The Sizewell C Project Case Team
National Infrastructure Planning
sizewellc@planninginspectorate.gov.uk
(By email only)

Planning Inspectorate Reference: EN010012
Our Identification Number: 20025459

Planning Act 2008 – Application by NNB Generation Company (SZC) Limited for an Order Granting Development Consent for The Sizewell C Project

Deadline 10 Submission

Figure 1.1: Locations of Unit 1 cooling water intake head position options (two to be installed) at the offshore Coralline Crag.

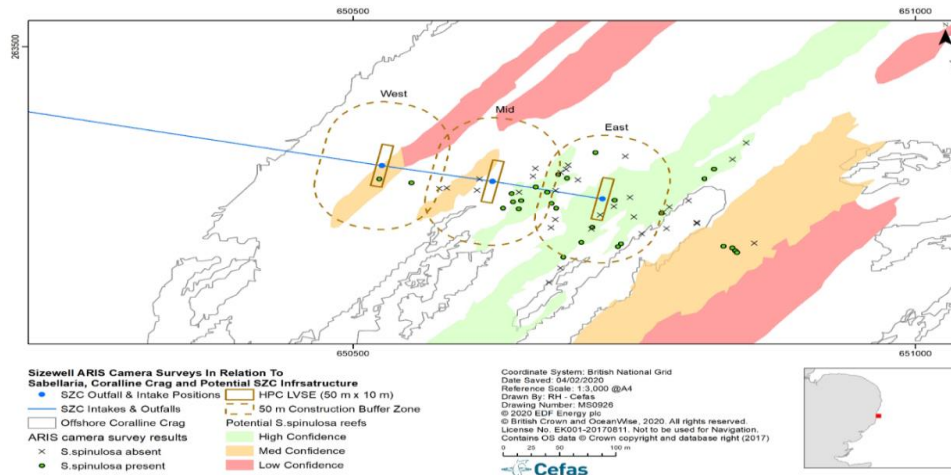
- 2.4.1 The MMO has reviewed the Draft *Sabellaria* Reef Management and Monitoring Plan [REP7-078] and have the following comments to make. While it has identified possible options for installation of the intake heads (jack-up, dynamic positioning, anchored barge), the mitigation plan does not commit to adopting the least environmentally damaging option. We note that at Hinkley Point C (“HPC”), an anchored barge is being used for installation of the intake heads. This is probably the most damaging option for *Sabellaria* reef. The MMO therefore requested further clarification from the Applicant about how the preferred construction option will be determined.

- 2.4.2 The Applicant has proposed to submit a revised version of the plan at Deadline 10. The MMO emphasise that this updated plan should be reviewed alongside our comment above. We understand that the plan submitted at Deadline 10 will include reference to careful planning of anchoring, however the MMO retain that any updates to address our comments should be explicit within the plan.
